Application by EPL 001 Limited: Stonestreet Green Solar Project (Application Reference: EN010135)

Responses to Section 51 Advice and Section 55 Checklist

Appendix 1- Responses to Section 51 Advice and Section 55 Checklist

2.3(B) Works Plans

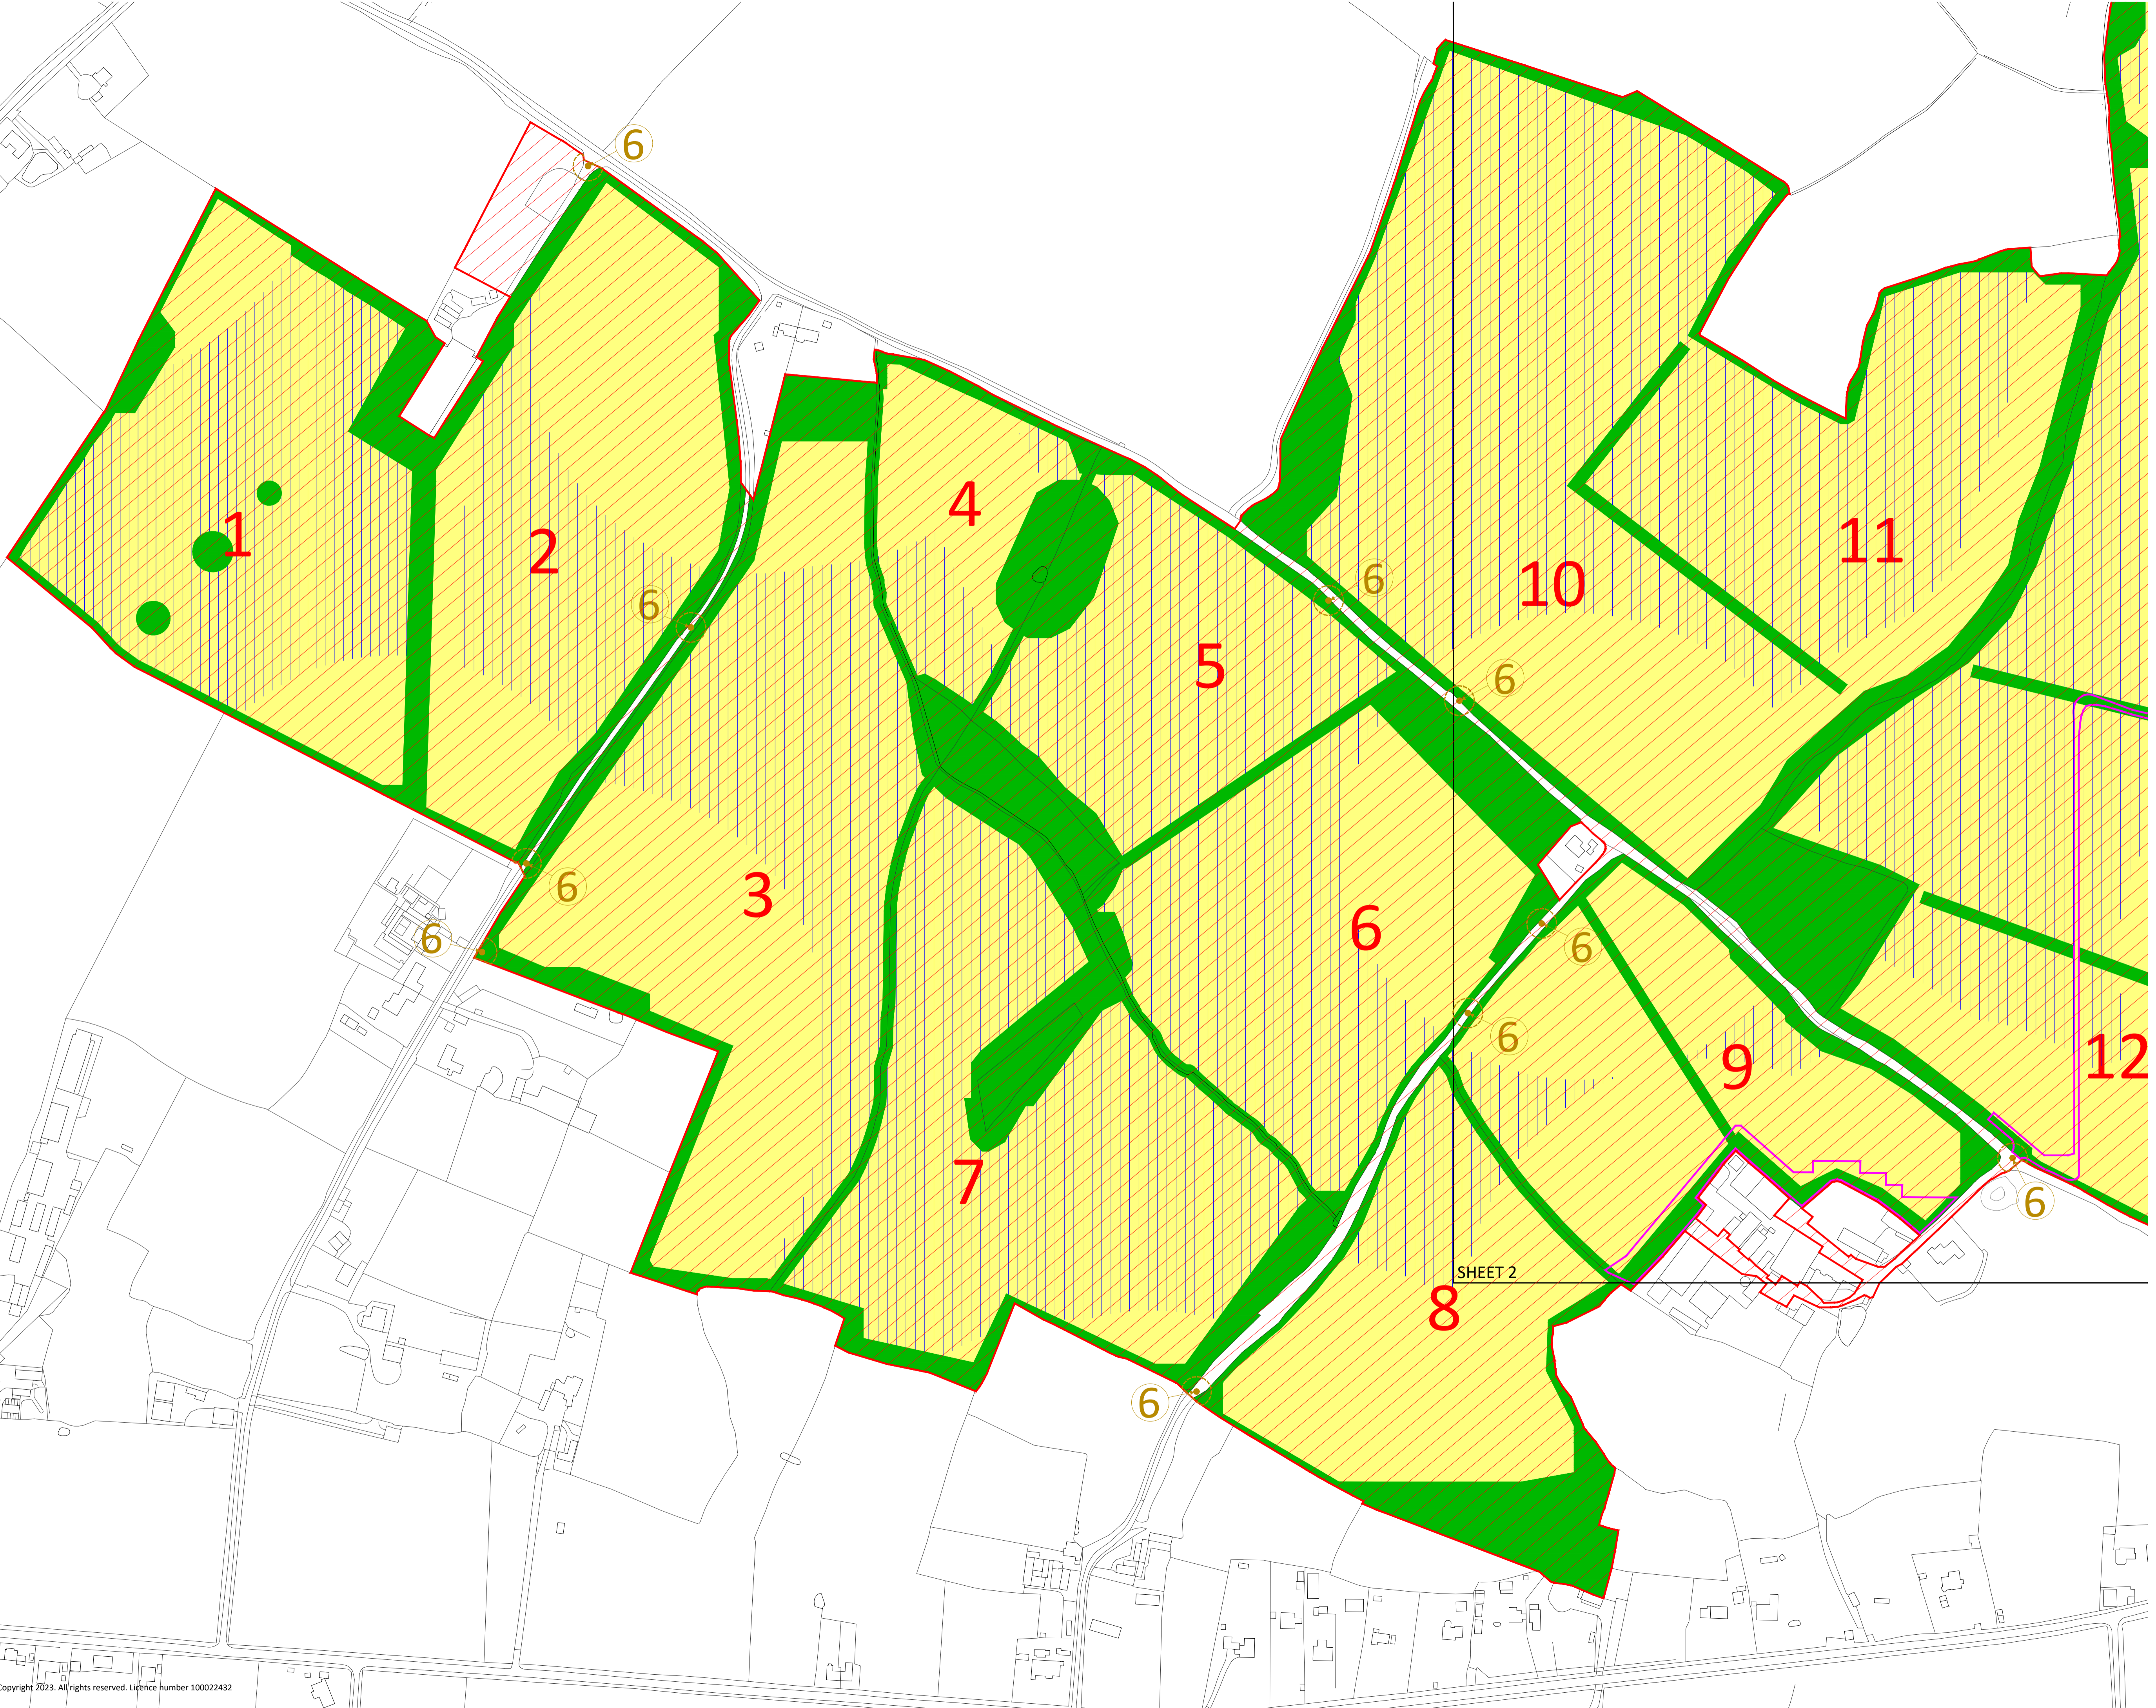
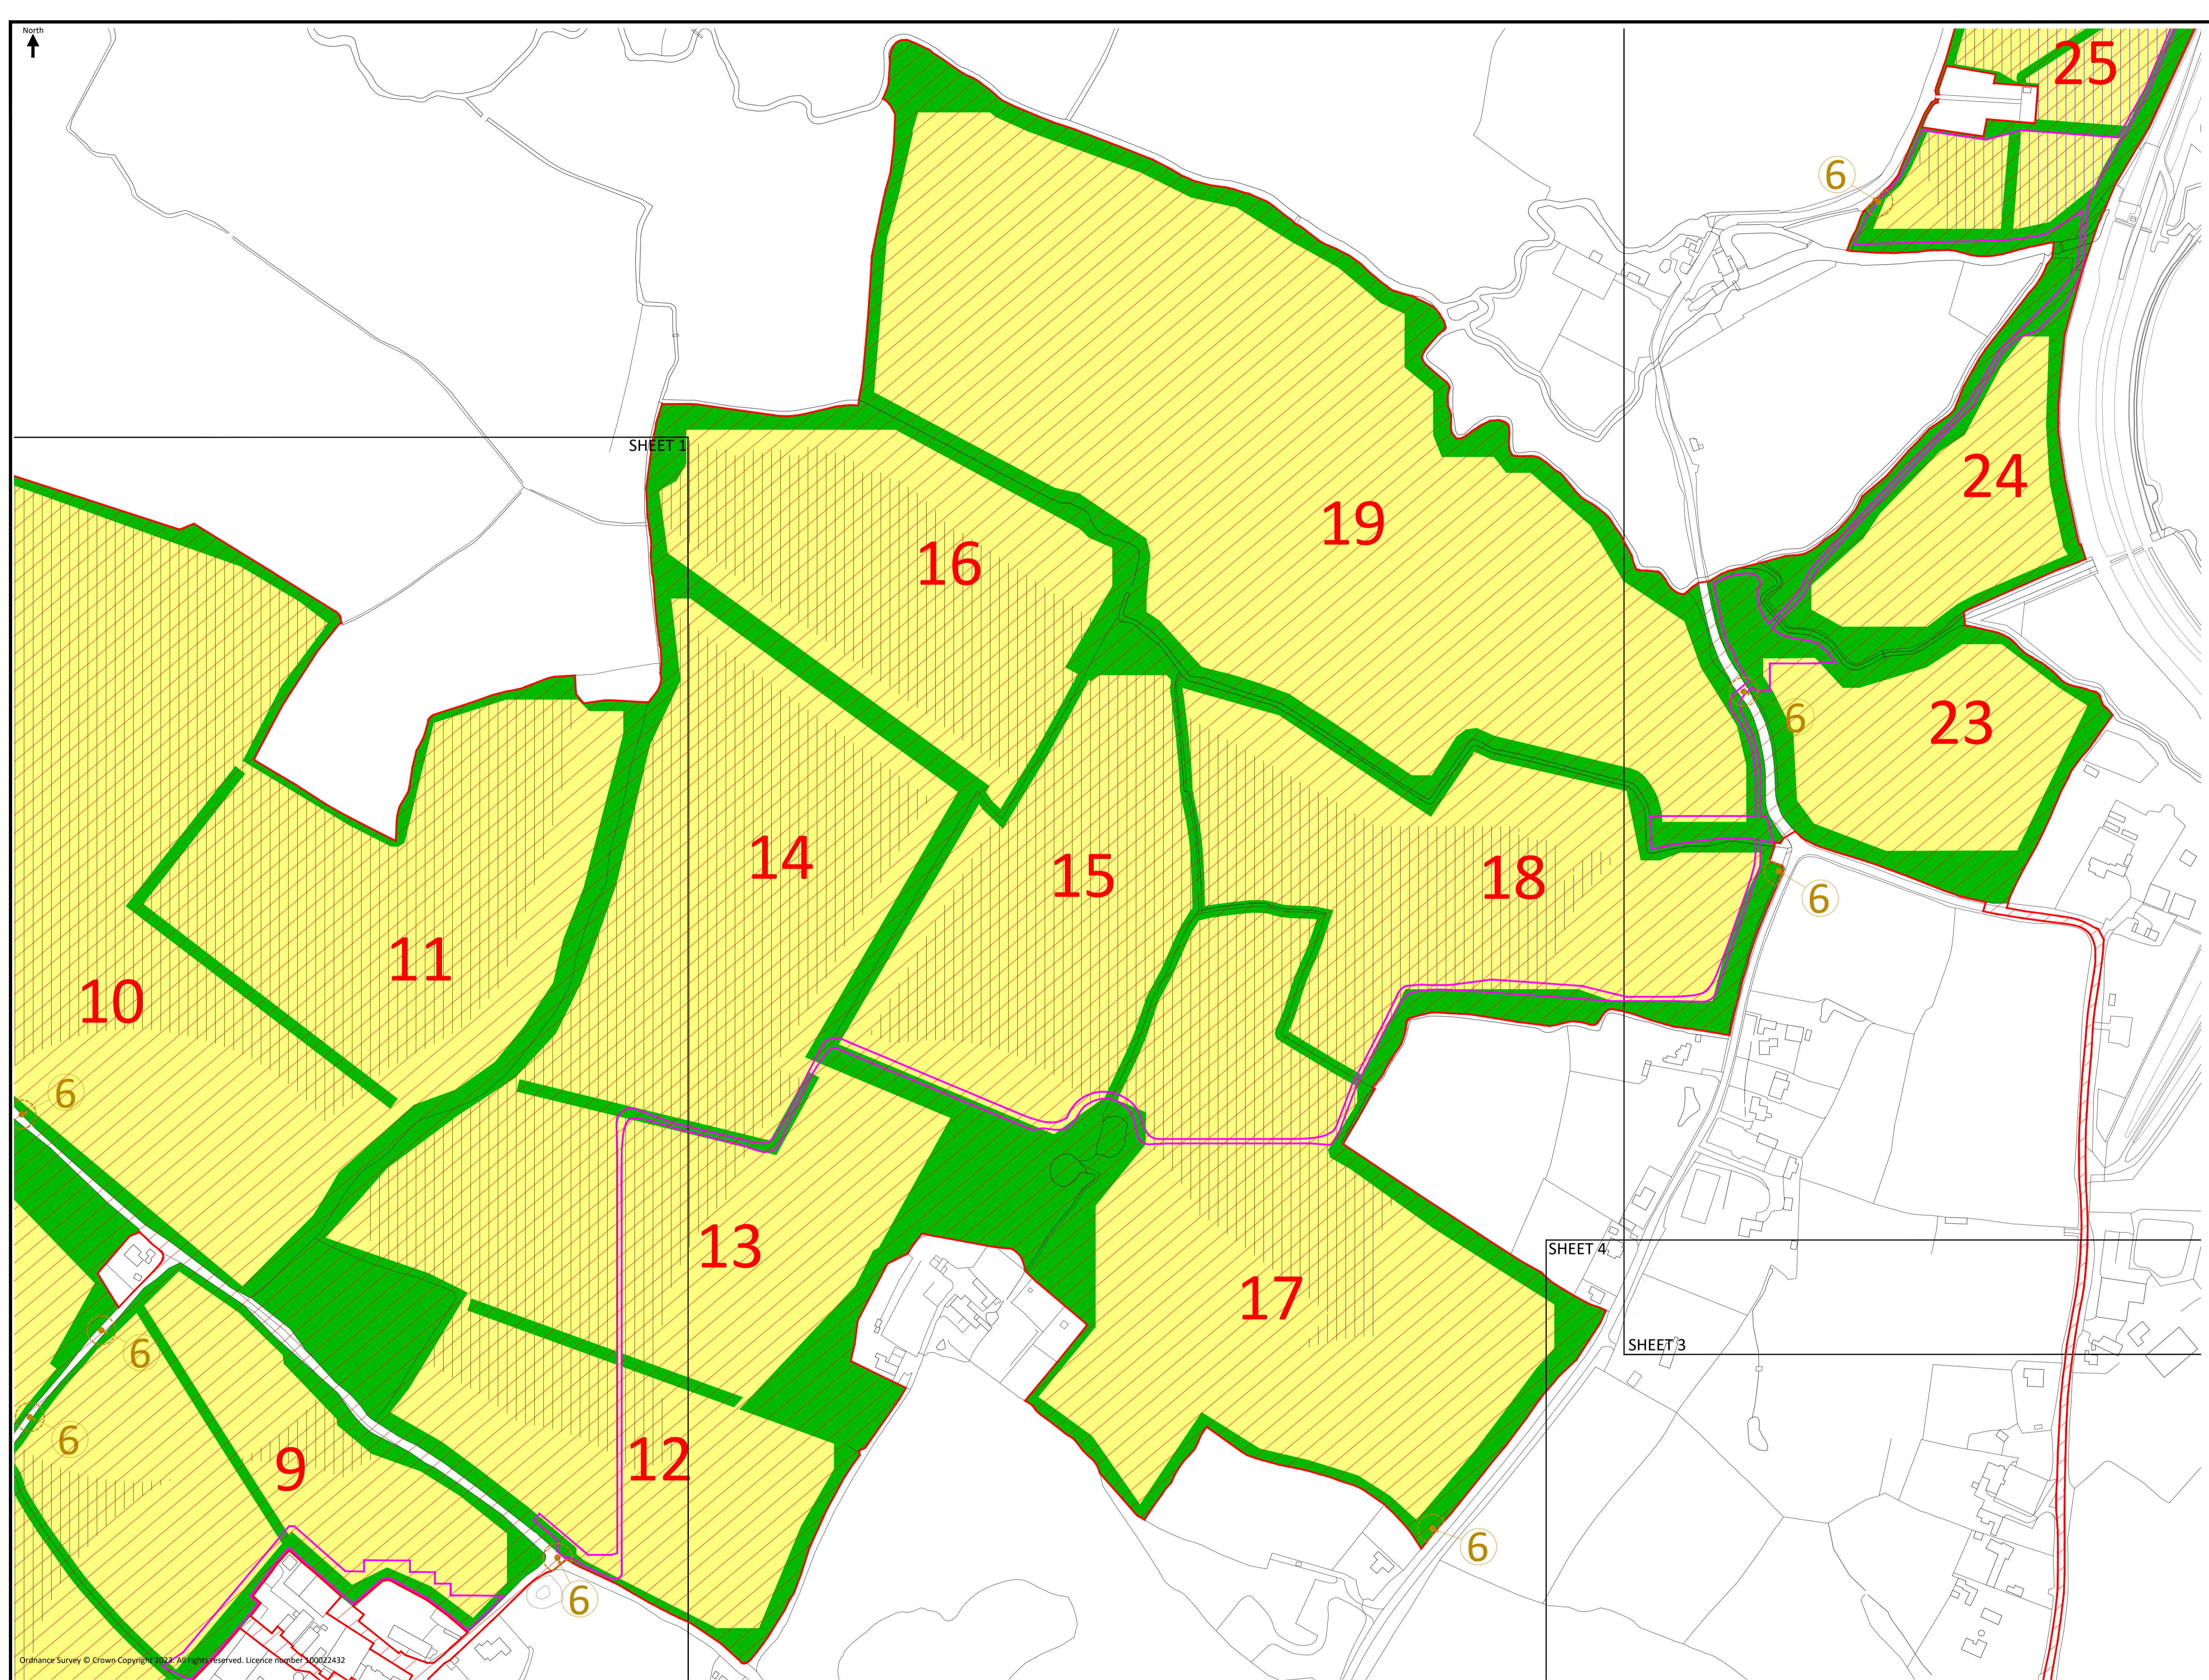
Section 51 Advice	Response
<p>The Works Plan (Doc 2.3) shows broad areas where the construction compounds could be located within Fields 8/9, 19, 20, 23, 25 and 26. The internal haulage road is also of a colour and design that is difficult to decipher from the remainder of the works that are shown on the Works Plan.</p>	<p><i>Goldwell Lane). Use of the internal haulage road for HGVs will avoid associated traffic, noise and other disruption to local road users and residents compared to the use of the local road network.</i></p>
<p>(Doc. 2.7) Illustrative Landscape Drawings – Not for Approval -There appears to be inconsistency on Section 4 Quested Cottage and Habitat Area– A proposed hedgerow is shown in a bold colour whereas ‘Proposed Tree and Shrub Planting’ are shown in fainter colours.</p>	<p>The appearance of the proposed planting on Section 4 is intentional. The bolder coloured vegetation is shown where the section line cuts through a feature, whereas the faded vegetation is in the background and shown in elevation. This has been done to provide depth perception.</p>

<p>We would advise that either the colour for the internal haulage road is amended to aid clarity or that separate plan is provided that shows both the location of the internal haulage road and the proposed construction compounds. We would also advise that clarification is provided as to the locations of the construction compounds within the Fields given their positioning could have an impact on the environment and amenity.</p>	<p>As noted above, the Work Plans (Doc Ref. 2.3) have been amended so that Work No. 7 is shown as a solid pink line. The line weight has been increased to make it easier to read alongside other Works.</p> <p>The maximum extents of the construction compounds (Work No. 7) are shown on the Work Plans (Doc Ref. 2.3) and then described in Chapter 3 of the Environmental Statement (Doc Ref. 5.2). See extracts below:</p> <p><i>“3.11.2 Two Primary Construction Compounds / primary decommissioning compounds will be located in Fields 25 and 26 as shown as Work No. 7 on the Works Plans (Doc Ref. 2.3)...”</i></p> <p><i>“3.11.4 Four Secondary Construction Compounds will be located in Fields 8/9 (adjacent to Bank Farm), 19, 20 and 23 as shown on the Works Plans (Doc Ref. 2.3).”</i></p>
